**TO:** All Staff  
**FROM:** Public Works Plan Review Team  
**DATE:** August 22, 2025  
**SUBJECT:** RU-25-00002 Dvorak

SUBJECT: WDFW COMMENTS ON RU-25-00002 Dvorak

**RE: SEPA 202503322; RU-25-00002**

*RE: Dvorak Reasonable Use (RU-25-00002)*

SHEET TITLE: SITE PLAN

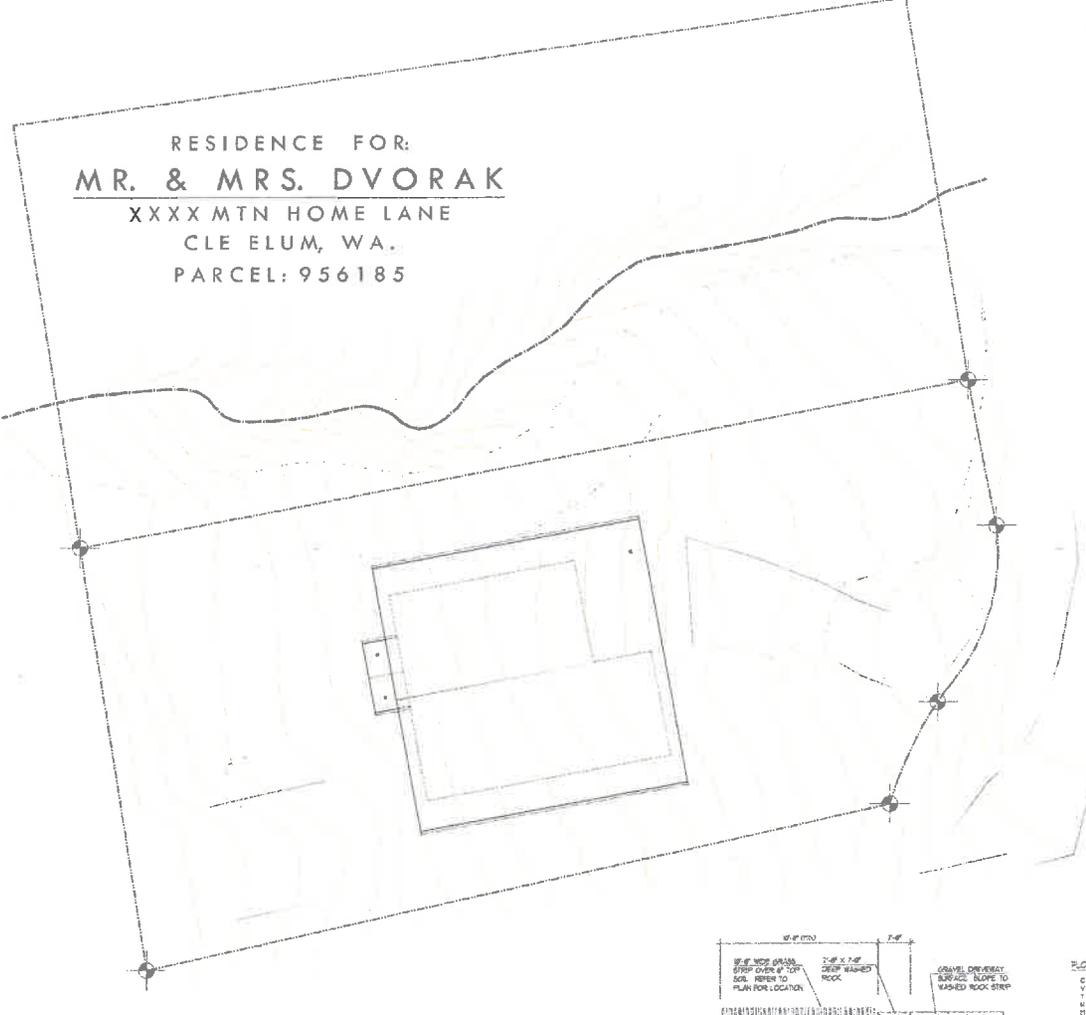
As observed during our site visit, there is a perennial stream flowing through the parcel, as referenced in the critical areas report. The proposed home site is located within the riparian management zone (RMZ, CAO 17A.04.030) of the stream. To ensure no net loss, we recommend avoiding and minimizing impacts to the RMZ as much as possible by siting the home and associated infrastructure as far away from the stream as possible. Where impacts cannot be avoided, mitigation will be needed to offset the impacts to the riparian buffer.

We appreciate the critical areas report, including proposed mitigation, included with the application materials. As discussed during our site visit, a planting plan should be developed following the metrics in the critical areas report – 7400sqft of planting, approximately 40 trees and 60 shrubs. Planting should occur on both sides of the stream. WDFW shared a list of native riparian plants for additional plant species consideration. The planting plan should include monitoring requirements to ensure survivability of the planted plants. We recommend at least three years of monitoring with an 80% survivability. If metrics fall below 80%, we recommend that similar plants be planted to replace those that did not survive. We request to review and provide concurrence to Kittitas County on the planting plan when finished.
